DELEGATED HOUSEHOLDER DECISION

77235/APP/2022/1373 - Erection of a single storey rear extension and conversion of roofspace to habitable use to include a rear dormer with a Juliette balcony and conversion of roof from hip to gable end. - Refused 22-06-22

An assessment of the plans and a site inspection has revealed that the main alterations between the as-built single storey rear extension (subject of this retrospective application) and the previously approved single storey rear extension (application reference: 77235/APP/2022/2138) can be

www.malathydesign.com 02037 462 100 074 6610 3263		ARCH./CLIENT —		Drawn BC	
Project Title 34A NORTHOLT AVENUE RUISLIP HA4 6ST		Checked			
Drawing Title EXISTING ELEVATIONS		Scale 1: 50	Size A2		
Project No. 2207/195		Drawing No. PE-03	Rev. C		
 Service in partnership with RMT

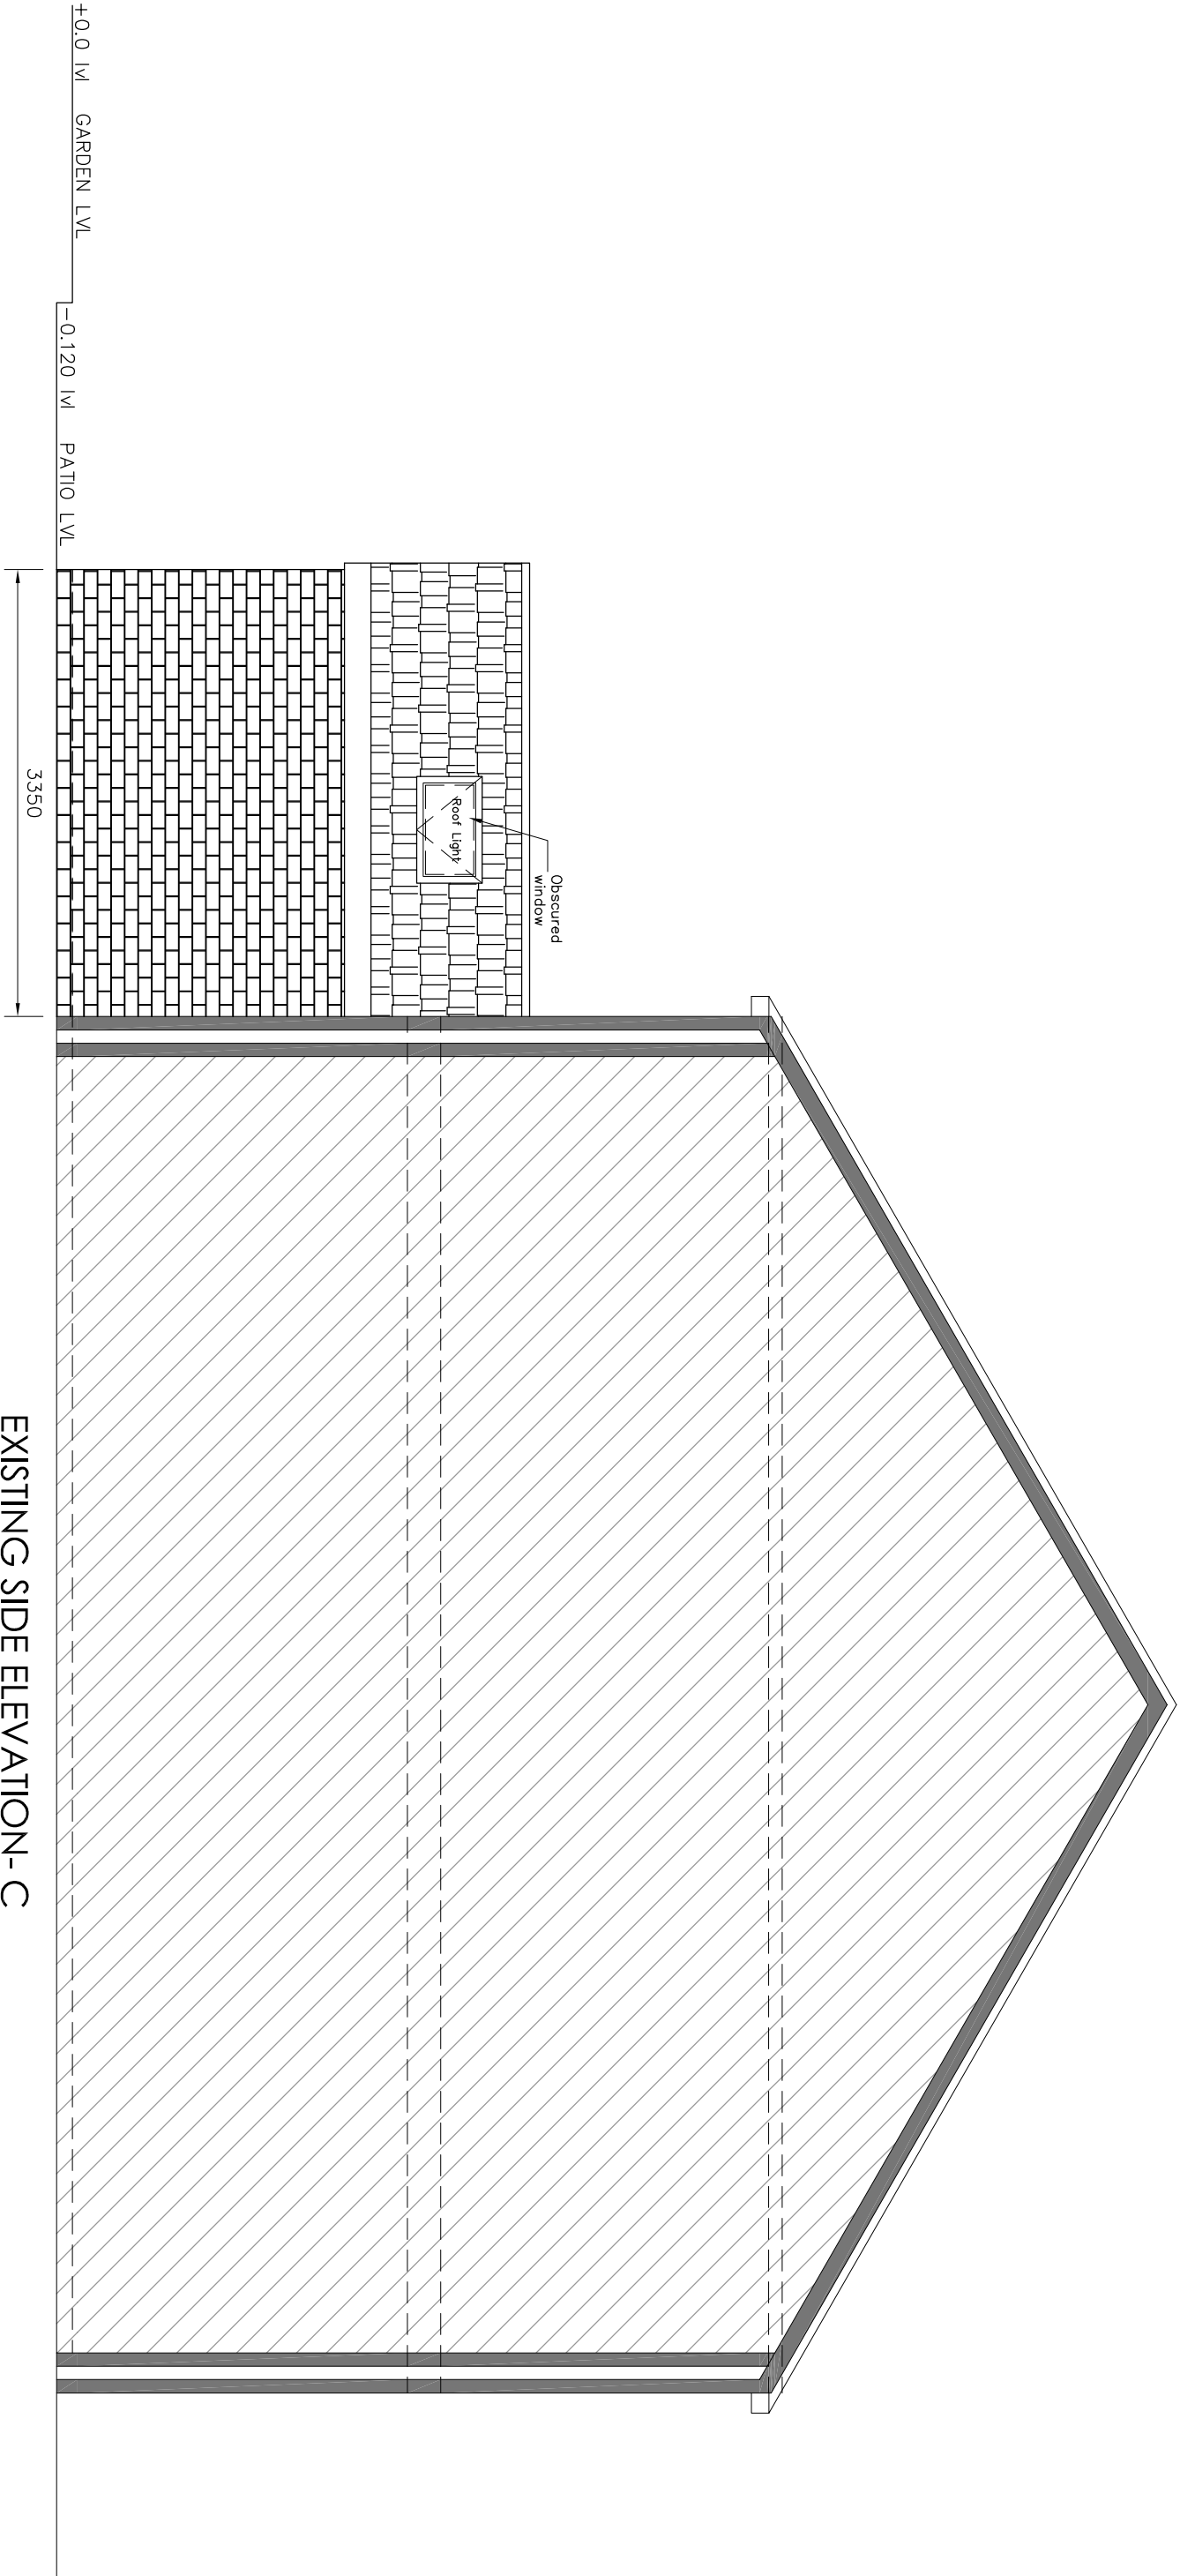
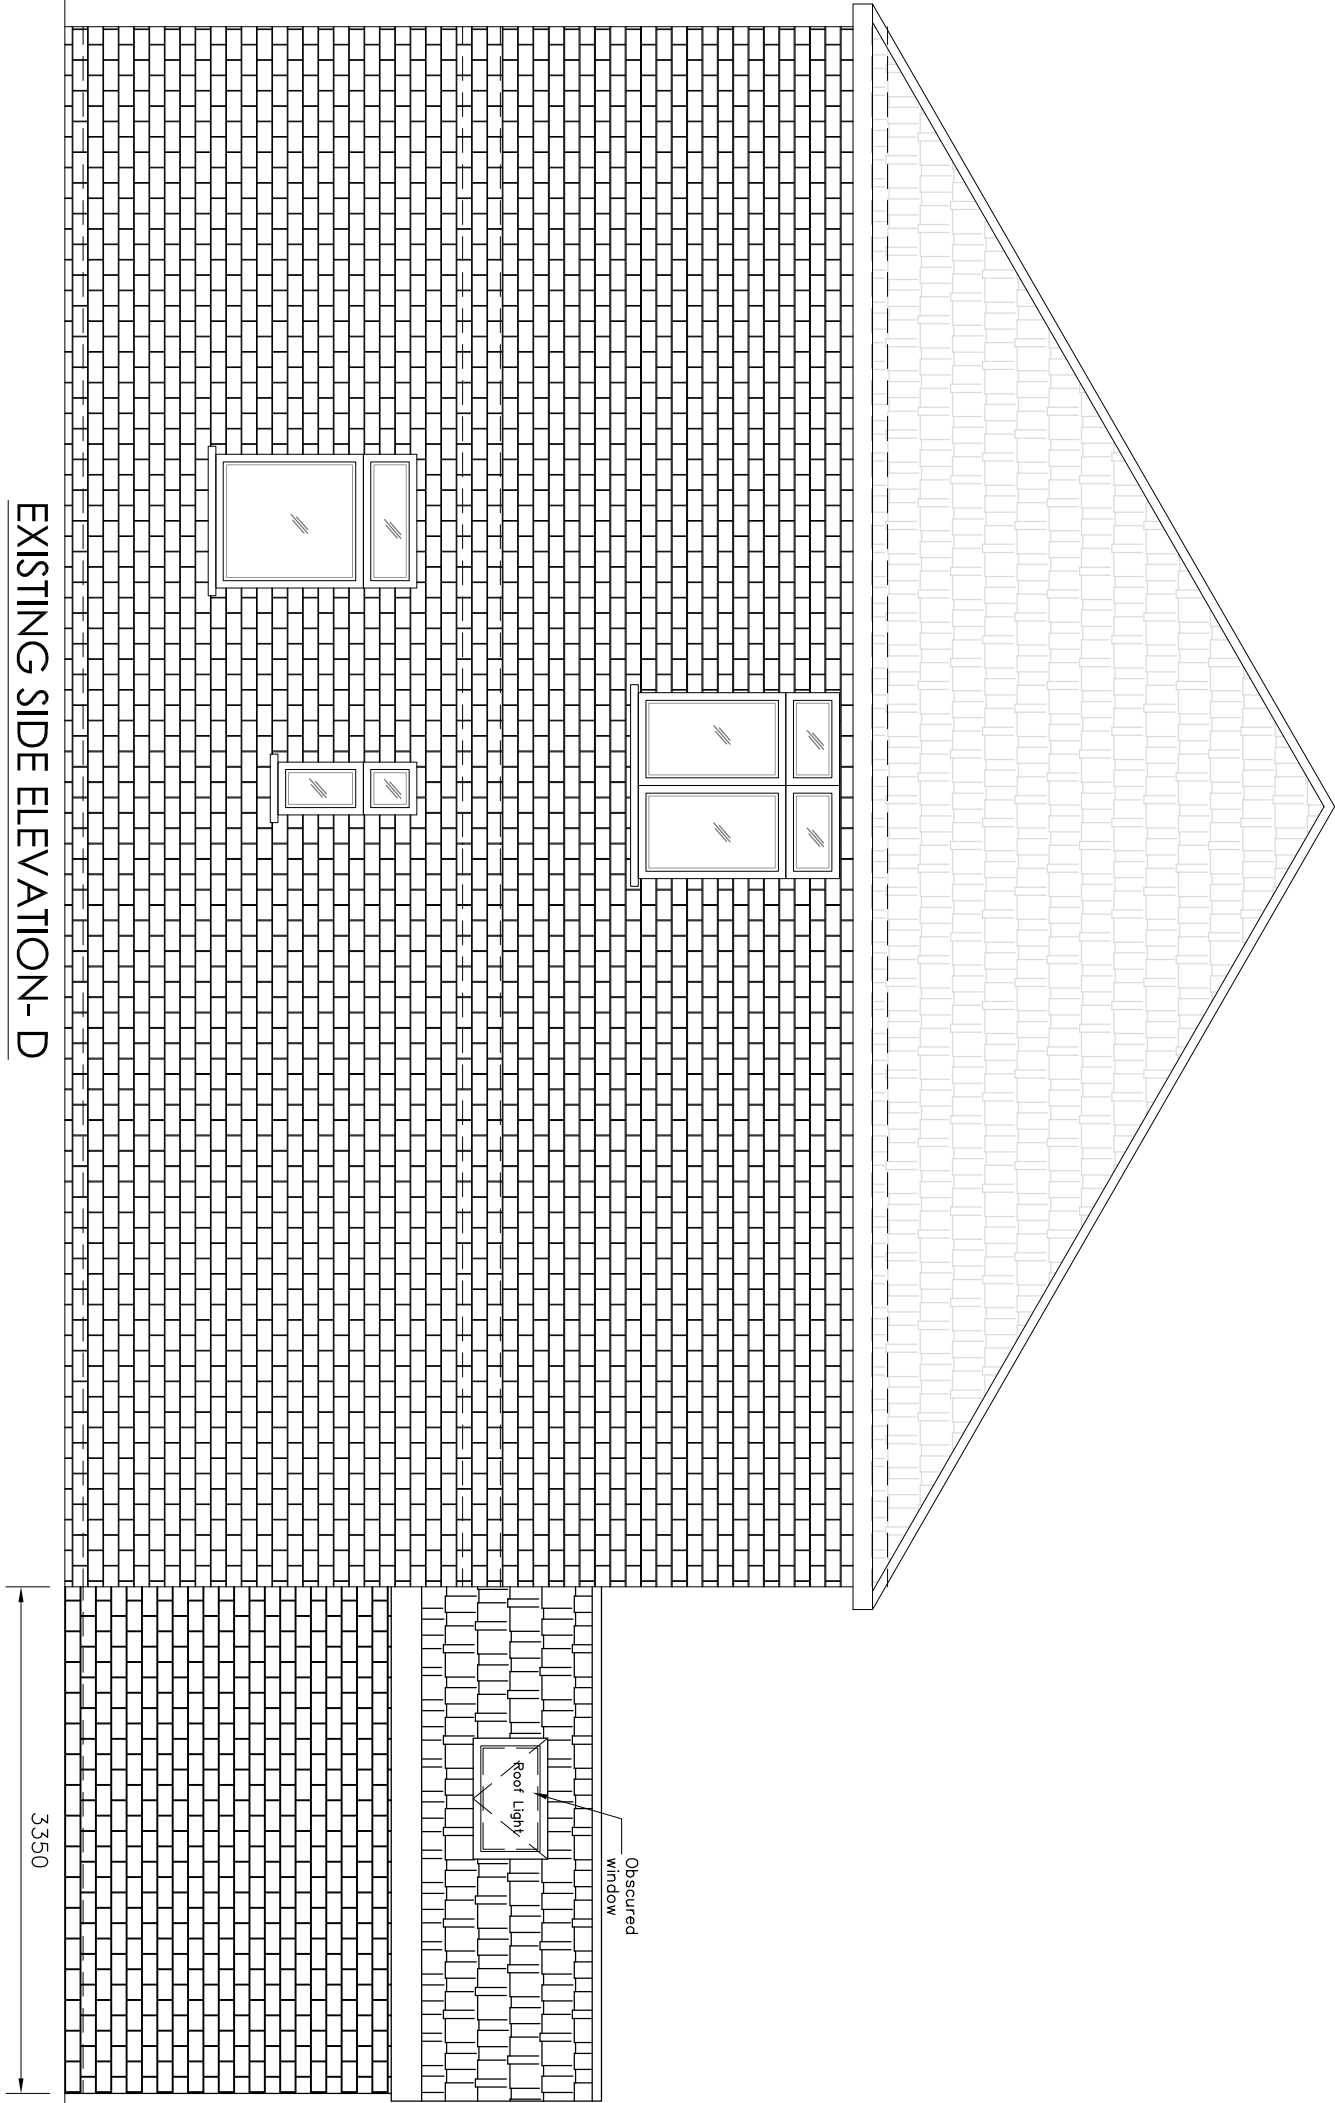
- Depth of the rear extension has increased from 3.3m to 3.35m;
- Eaves height has been increased from 2.25m to 2.4m;
- Maximum height of the pitched roof has increased from 3.15m to 3.54m and;
- Glazed panel below above bi-fold doors, replacing the approved brick work.

In terms of Policy DMHD 1, the proposed depth of the extension is policy compliant. The maximum height of the rear extension at 3.54m is marginally above the 3.4m threshold recommended in Policy DMHD 1, however it is noted that this is a marginal difference and the eaves height of the extension remains relatively low. The proposed glazed panel above the bi-fold doors is considered acceptable.

The proposed extension would extend 3.35m beyond the rear building line of the attached neighbouring property, 34B Northolt Avenue. The rooflights on the sides of the pitched roof are obscurely-glazed and would be 2.6m above the finished floor level. Given the modest depth of the proposed extension, the modest height of the proposed dual-pitched roof ridge and eaves and the obscure-glazed side rooflight, it is considered that the proposed development would not adversely harm the neighbouring amenity of 34B Northolt Avenue in terms of loss of light, outlook or privacy.

The development hereby permitted shall be retained and completed in accordance with the details shown on Drawing Nos. PE-02 Rev. C, PE-03 Rev. C & PE-04 Rev. C.
